Project# 1005357

TO: DRB Chair
FROM: Carmen Marrone, Senior Planner
RE: **Project #1005357, Oxbow Town Center**

Project# 1005357
07DRB-70392 MAJOR - PRELIMINARY PLAT APPROVAL
07DRB-70395 EPC/ SDP FOR SUBDIVISION

SURV-TEK INC agent(s) for OXBOW TOWN CENTER, LLC request(s) the above action(s) for all or a portion of Tract(s) X-1-A2 & X-2-A UNIVERSITY OF ALBUQUERQUE URBAN, **UNIVERSITY OF ALBUQUERQUE URBAN CENTER to be known as OXBOW TOWN CENTER**, zoned SU-3 (R-2,C-2, 0-1), located on ST JOSEPH'S DRIVE NW BETWEEN COORS BLVD NW AND ATRISCO DRIVE NW containing approximately 47.72 acre(s). (G-11)

SHEET TITLE: **SITE PLAN FOR BUILDING PERMIT**

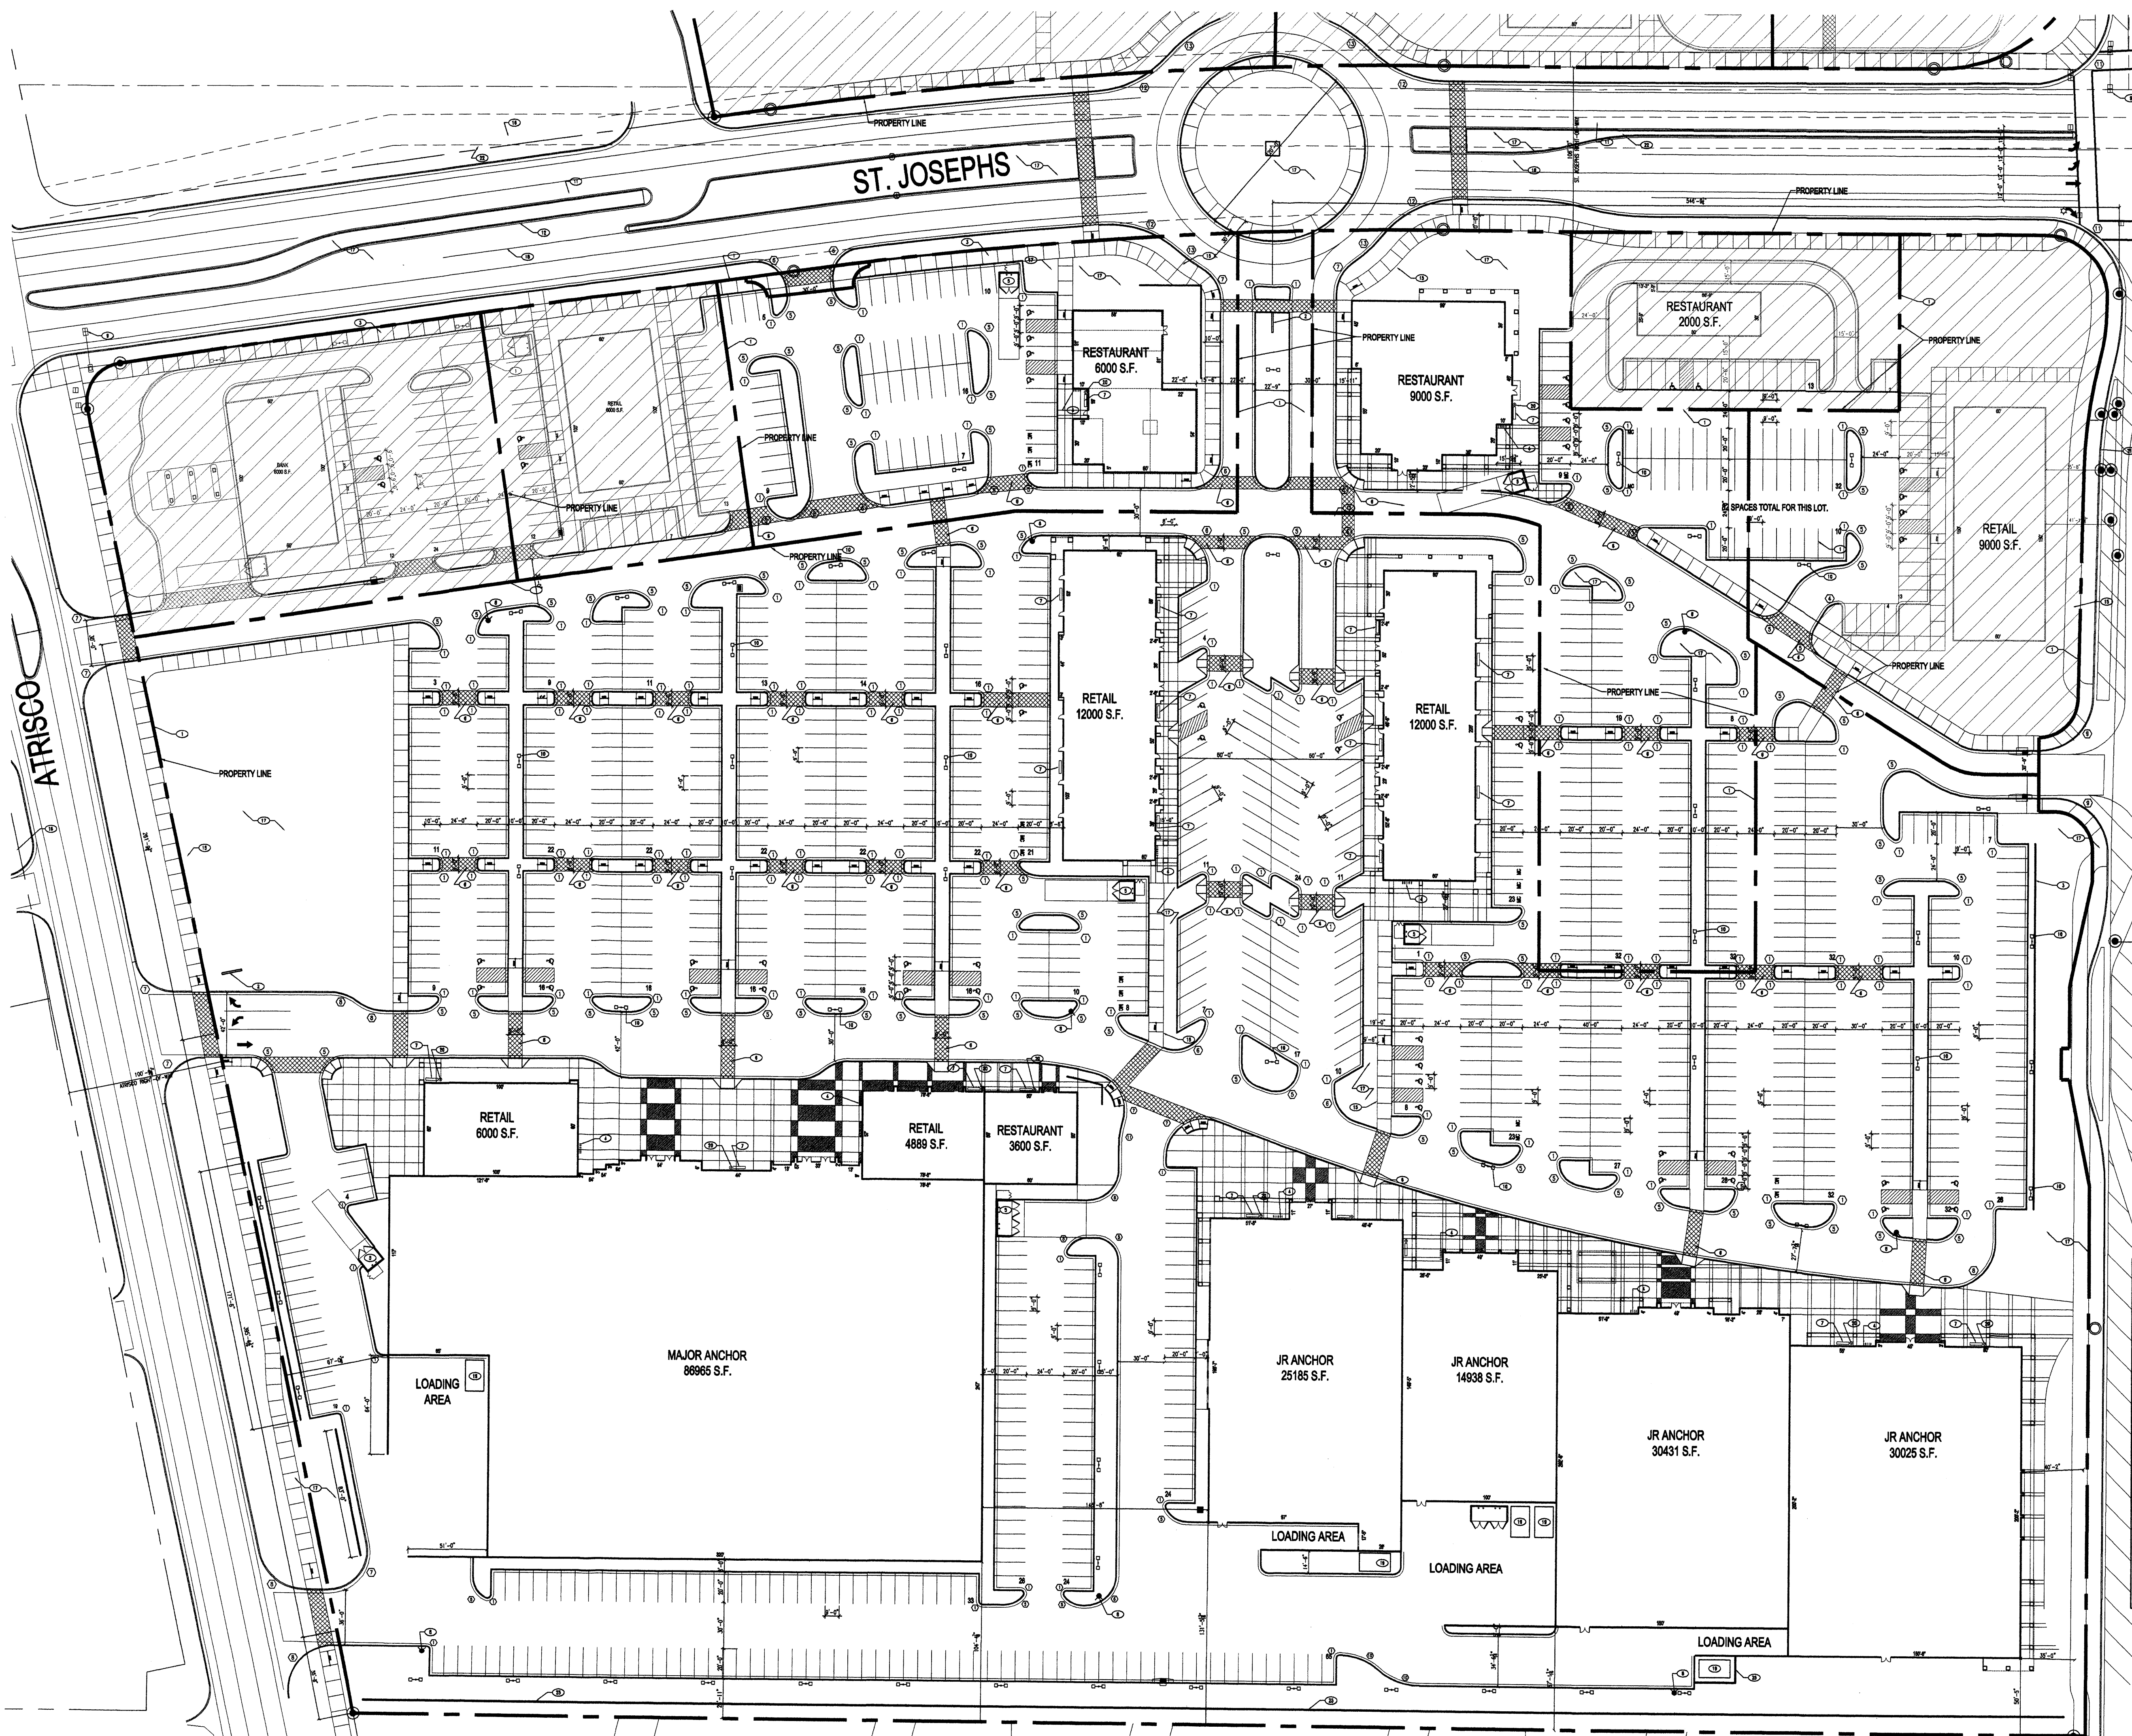
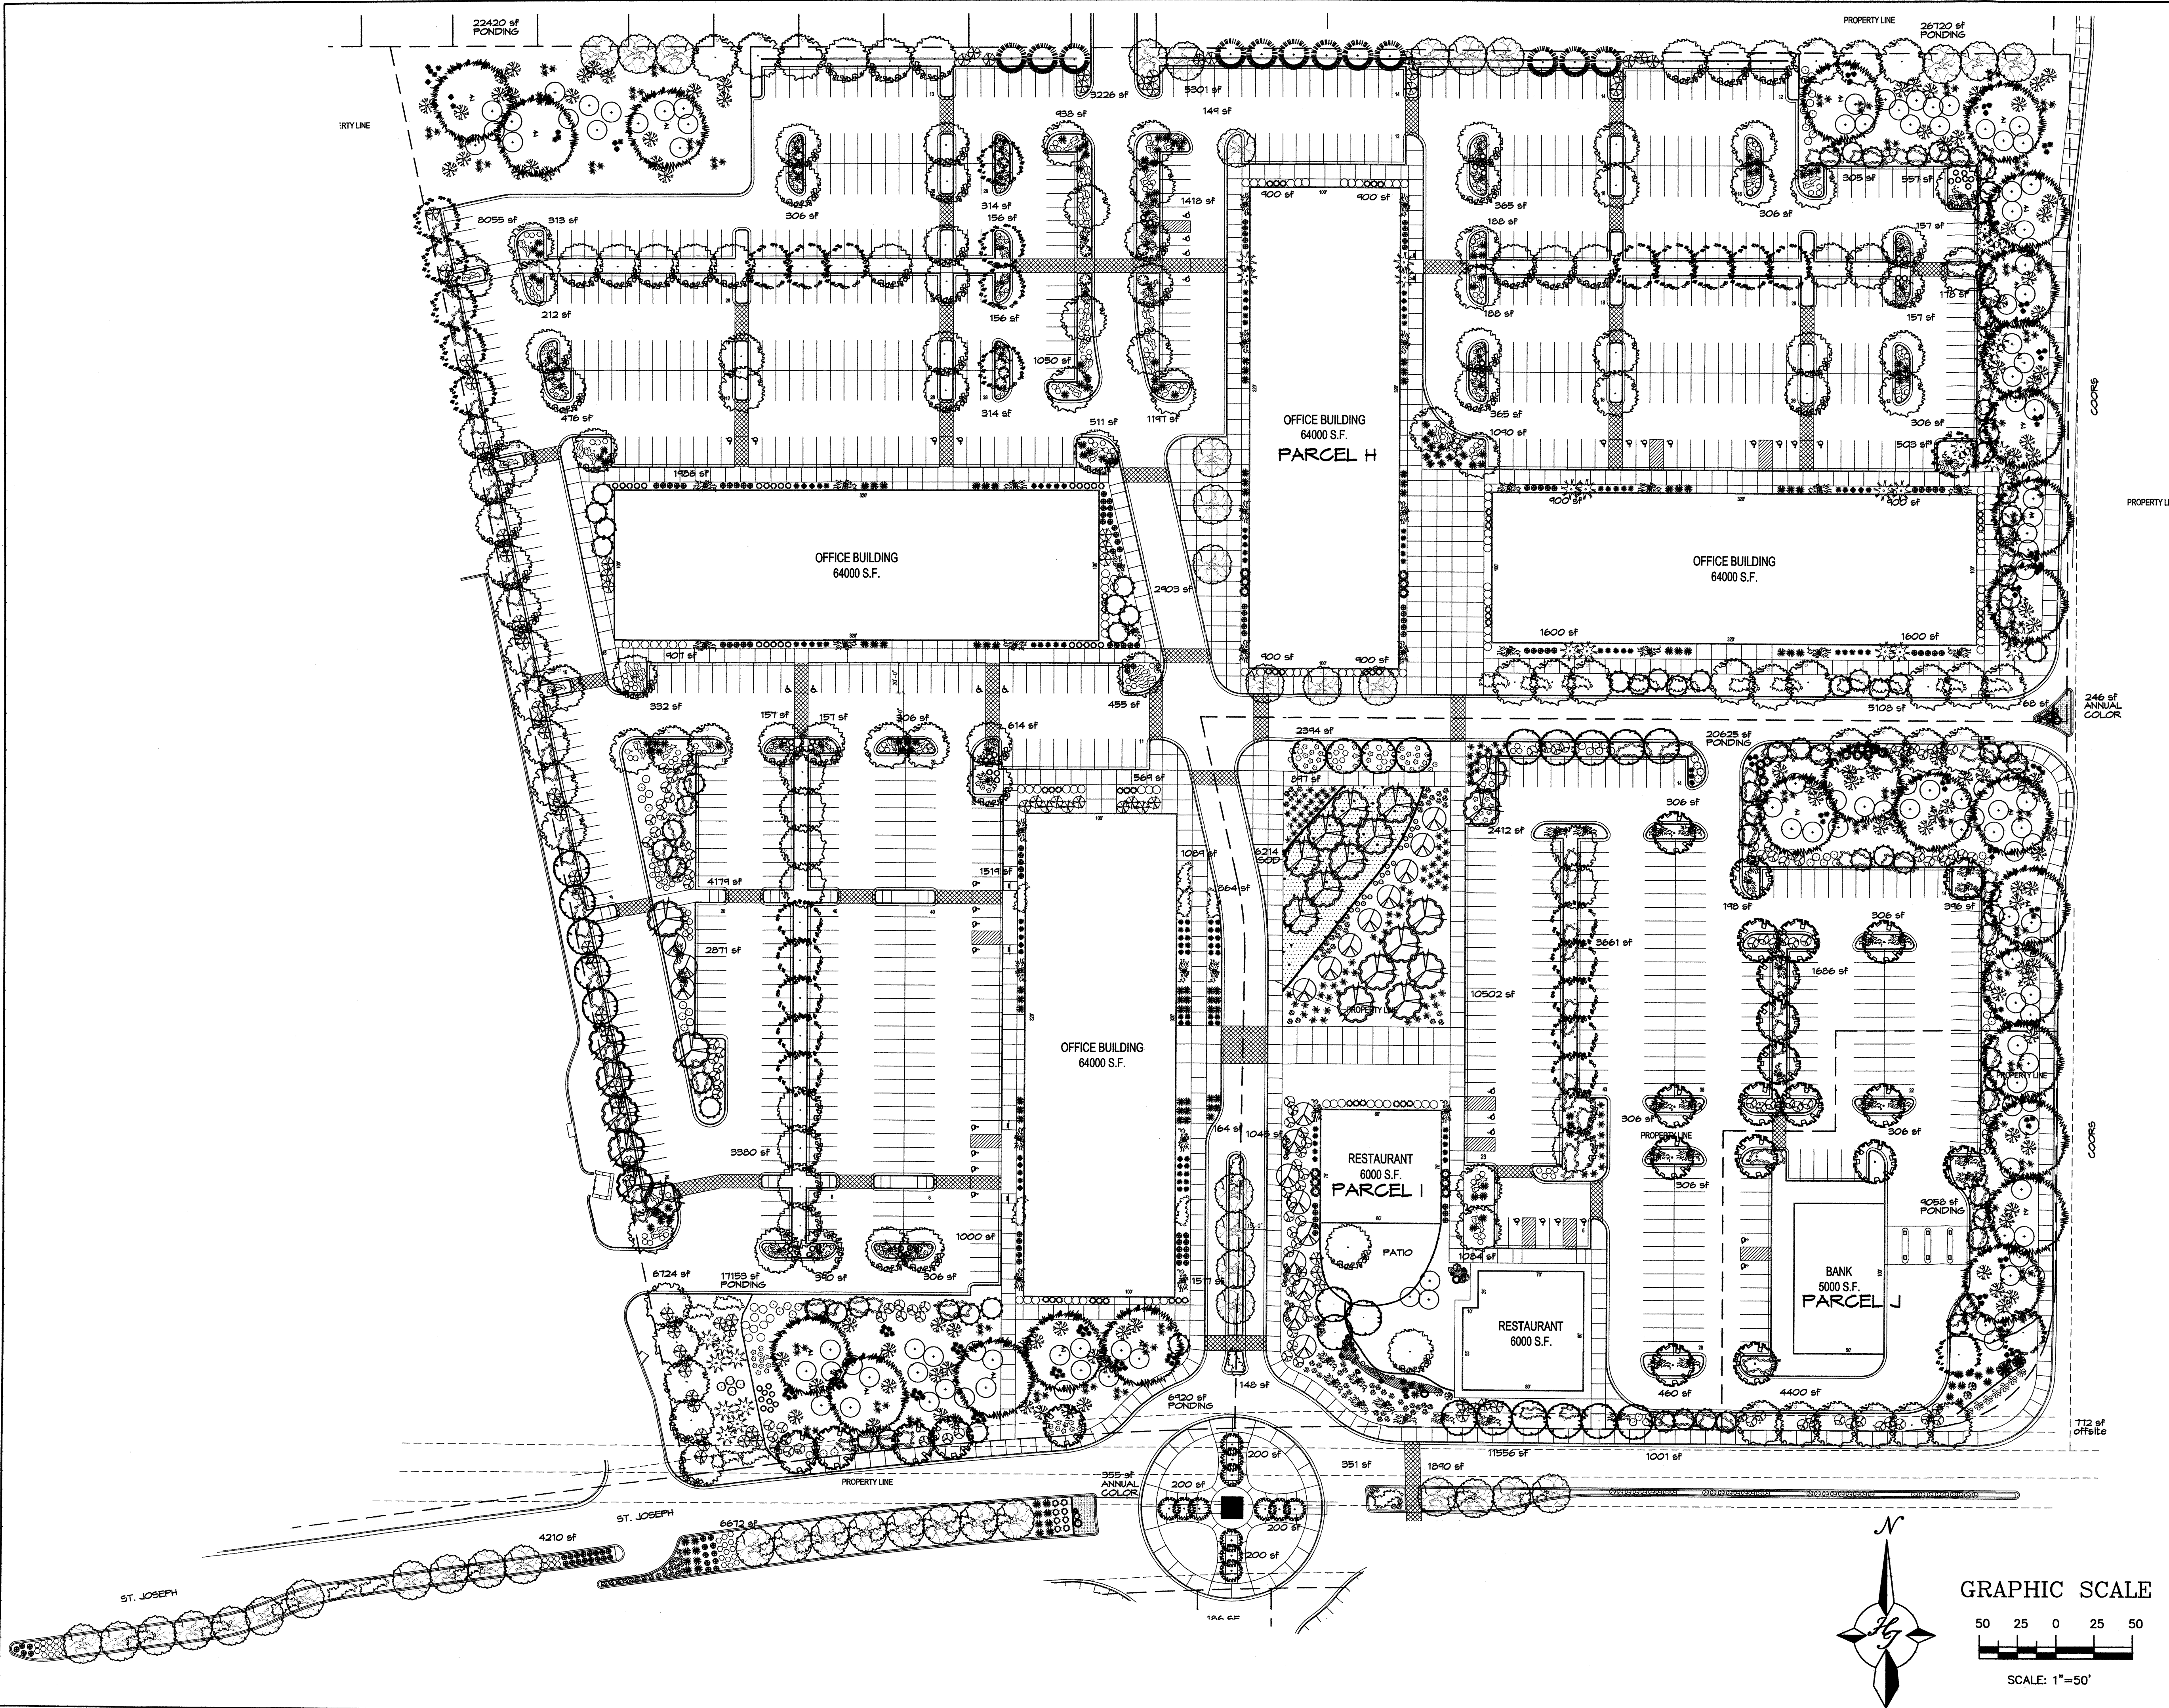
Provide an exhibit for Coors Blvd and St Josephs Drive showing the location of sidewalk and defining the distance from face of curb to the property line
